From: Simon Davis
Sent: 03 August 2022 10:09
To: Chris Pope [REDACTED]
Subject: RE: AW/104/22/PL 8 Gossamer Lane, Aldwick

Subject: AW/104/22/PL 8 Gossamer Lane, Aldwick

Drawing
Location, Site, Floor Plans

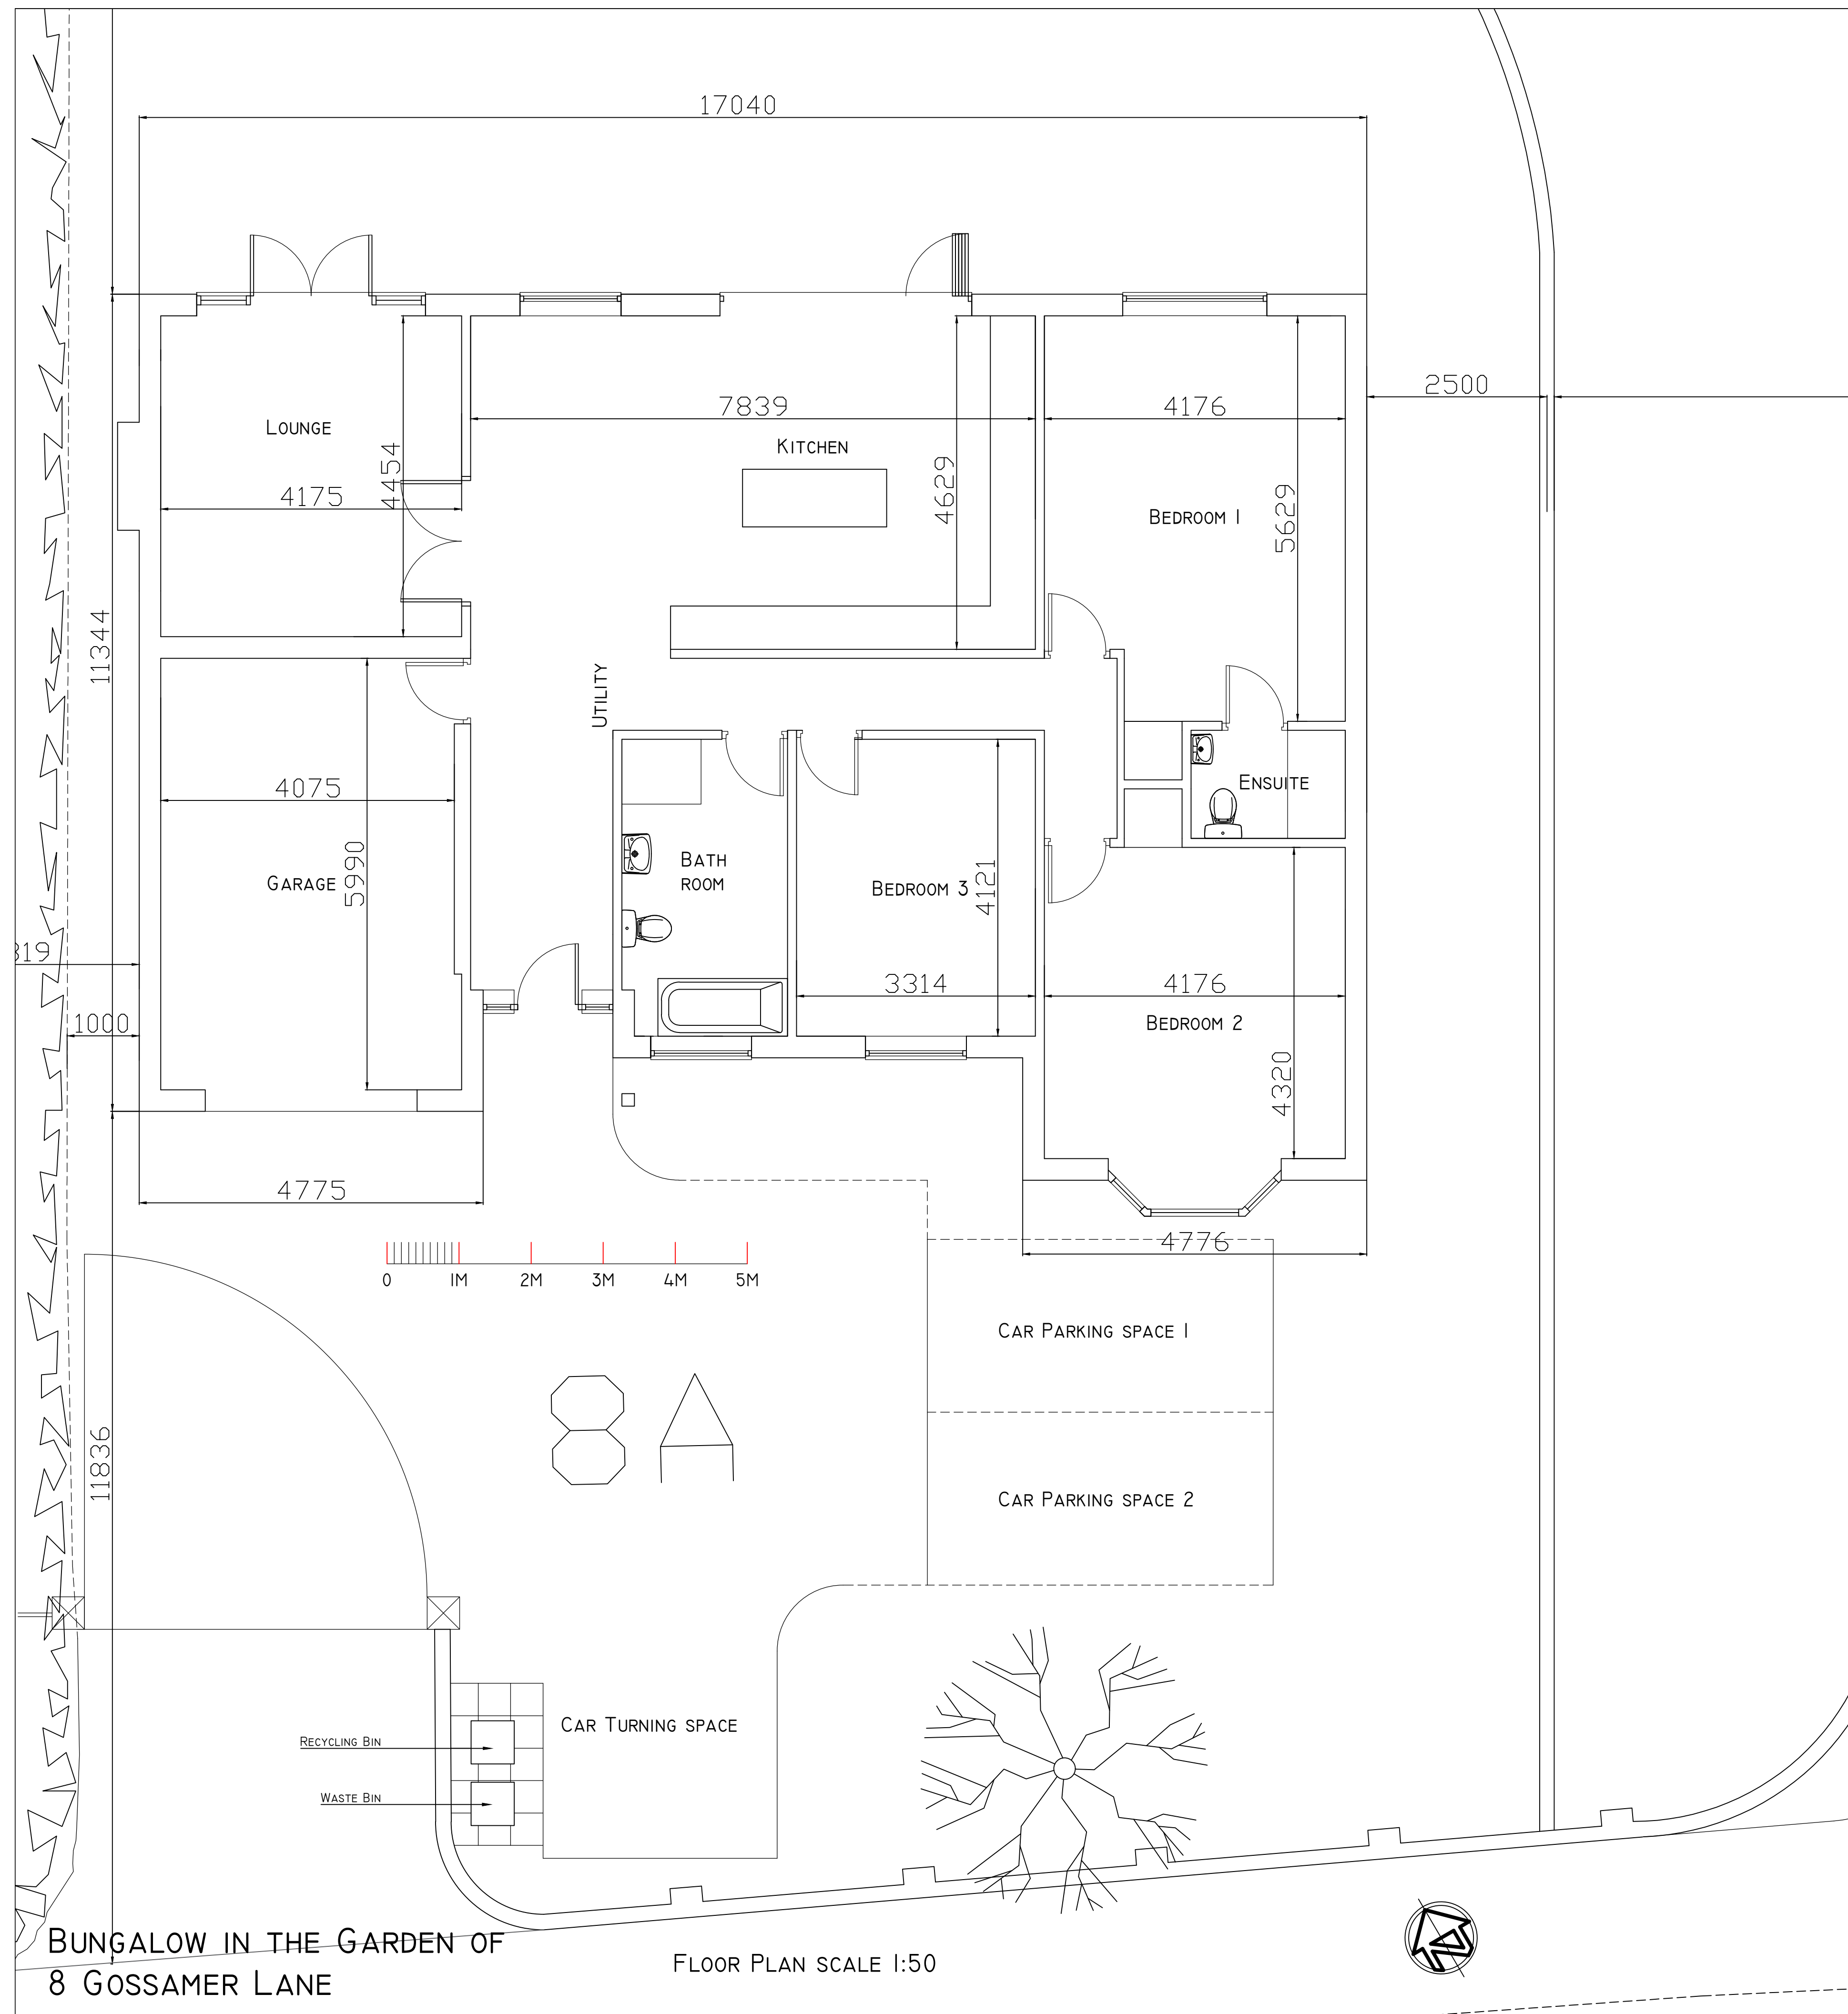
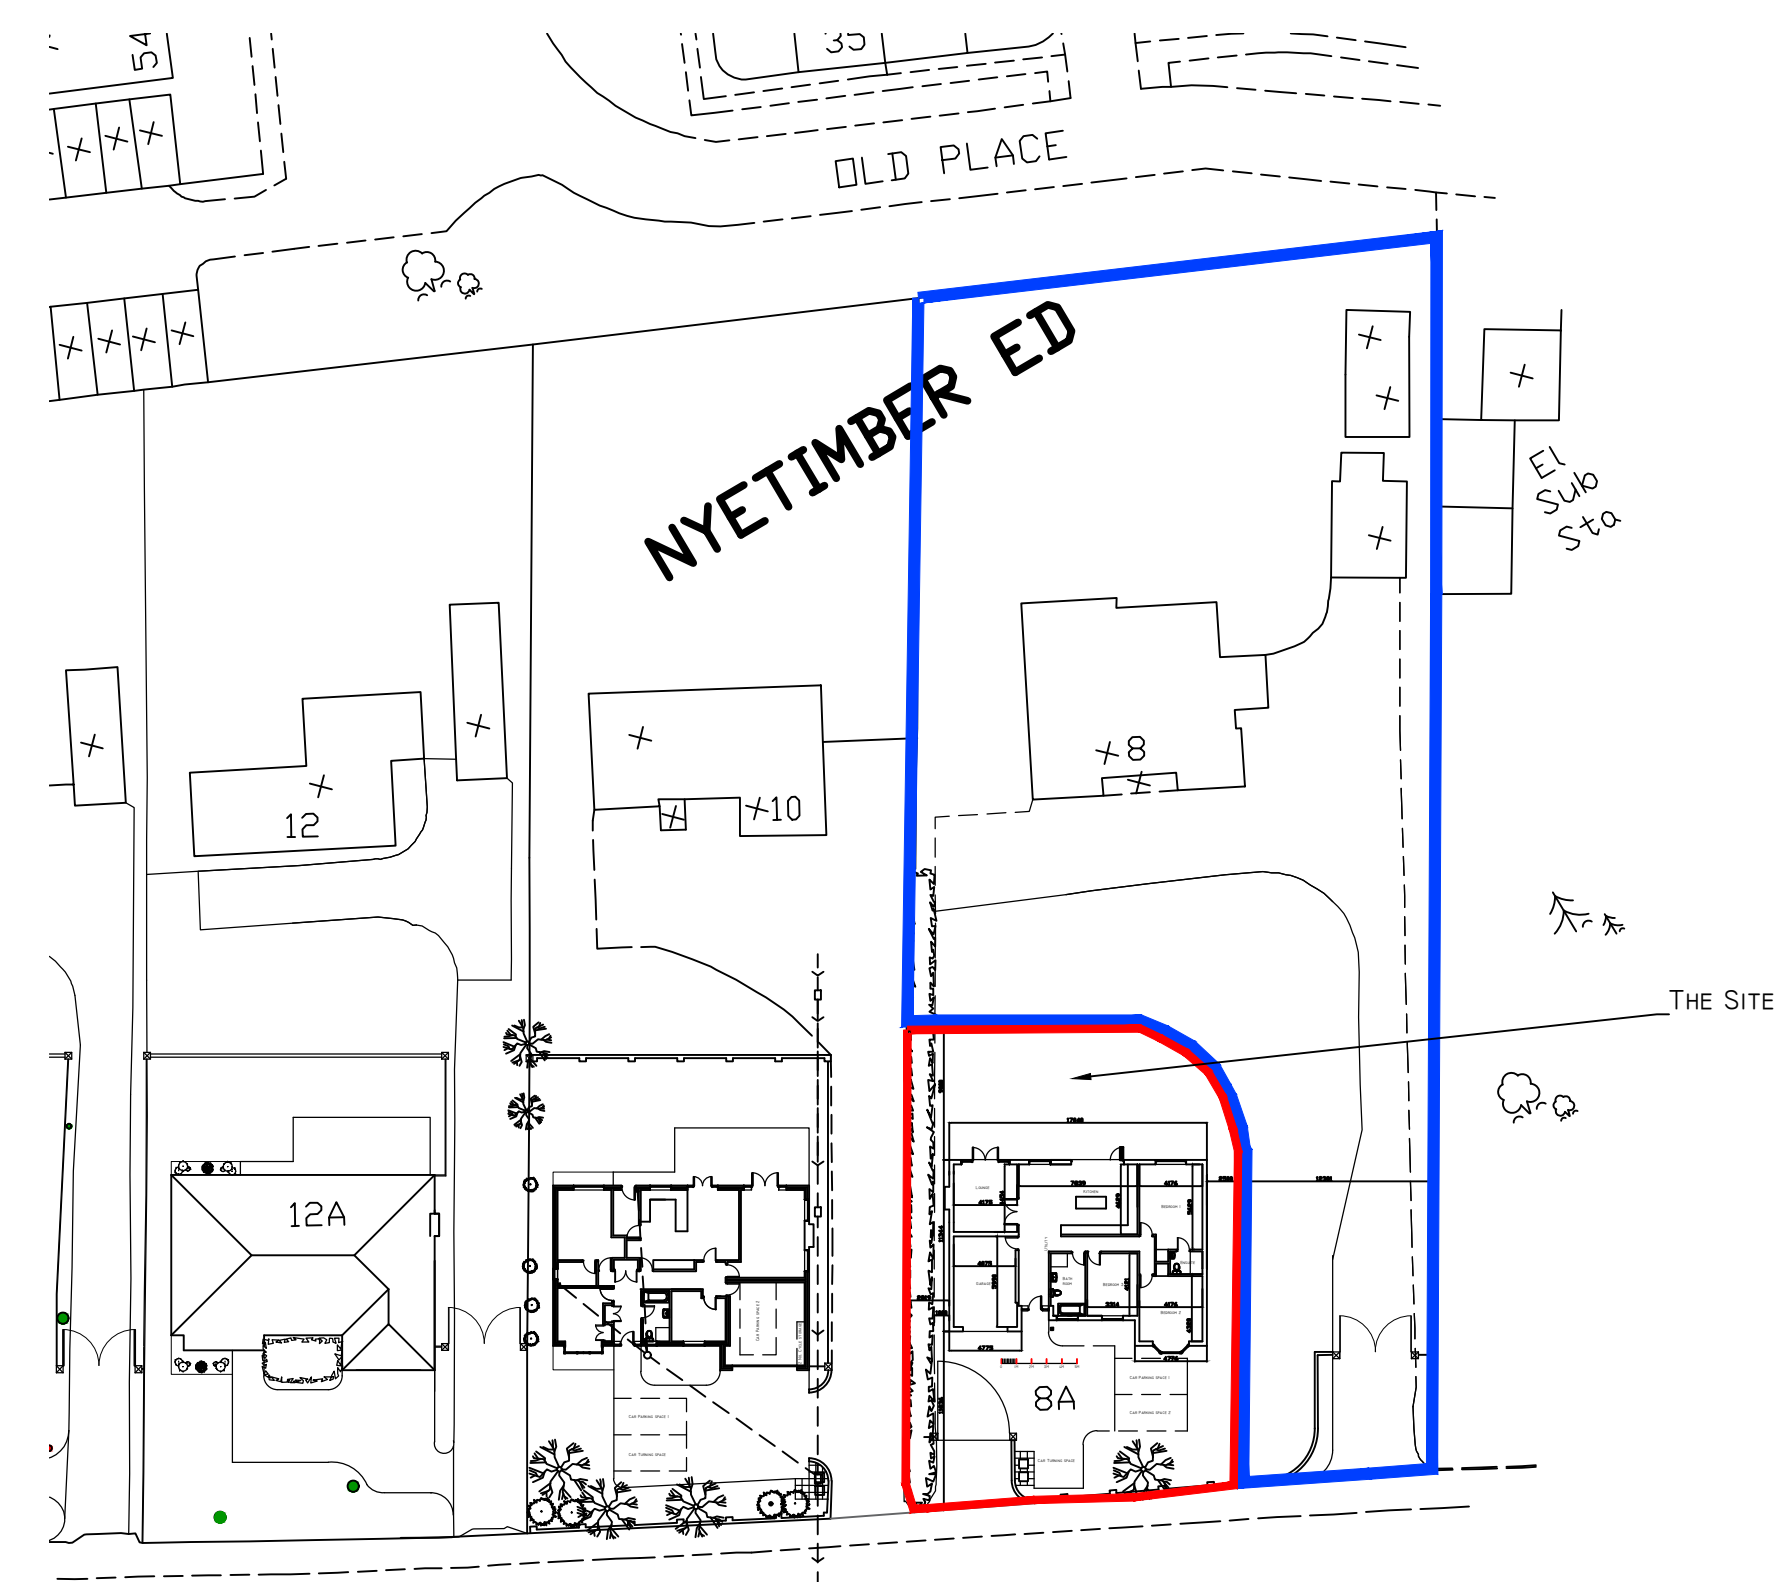
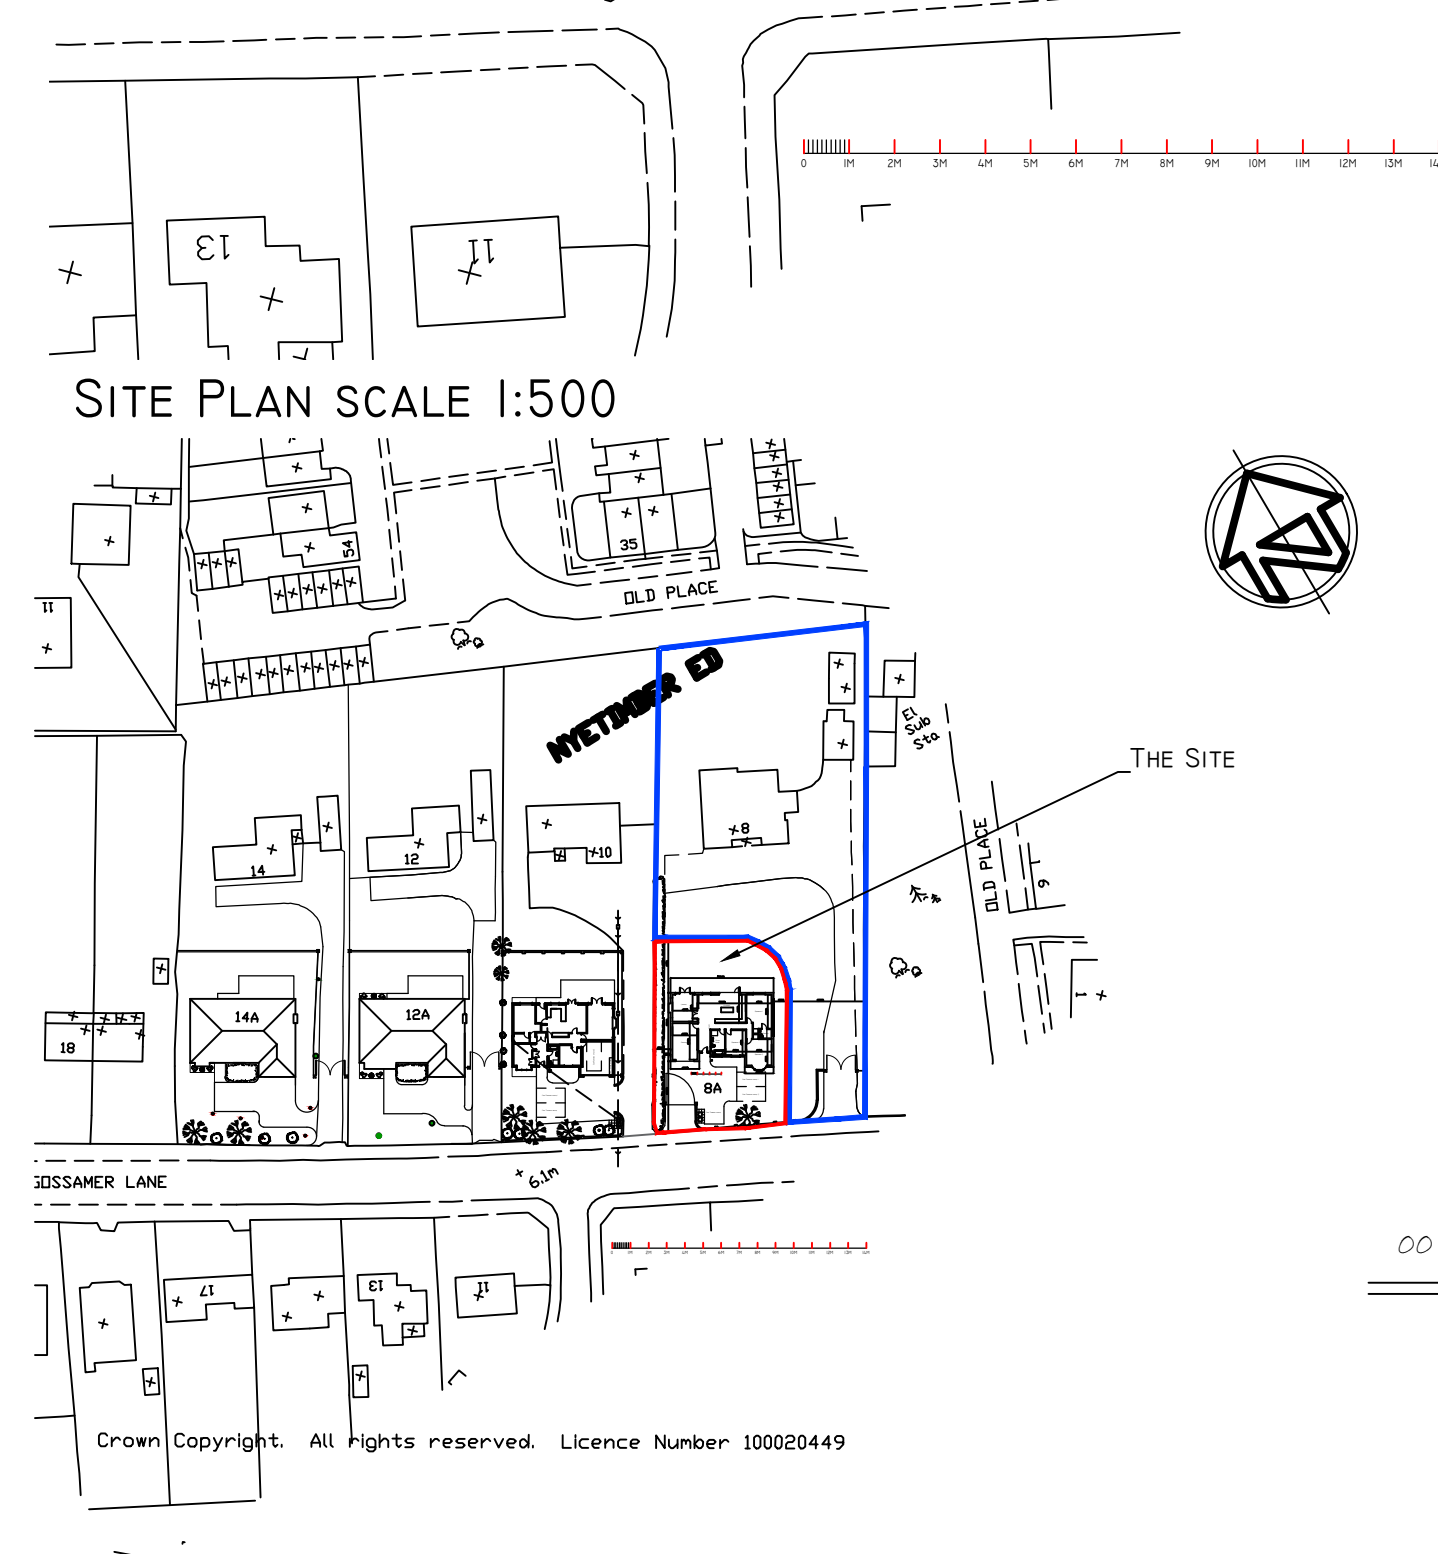
Our Conservation Officer has stated the following: *"It would appear that the existing (right hand) gate pier to the eastern access point, matches one found within the (Grade II Listed) Old Place development walling. It is recommended that this be retained in position as part of the alterations to the access points. Likewise, the remainder of the existing walling, whilst clearly modern, makes a positive contribution to the street-scene, and every attempt should be made for any alterations and new work to match the existing."*

I note that the gate pier falls within the blue not the red edge but can you confirm that no changes are proposed to the existing eastern access so that the pier can remain as is. I believe this to be the case but just need confirmation.

I can confirm that the existing Eastern pillar of the right hand gate (when viewed from Gossamer Lane) will not be changed or moved in any way. The left hand pillar will be widened by approx 1m and will reuse the original material so as to match the current gatepost as far as possible. The reason for the widening is to improve the visibility and access into the drive.
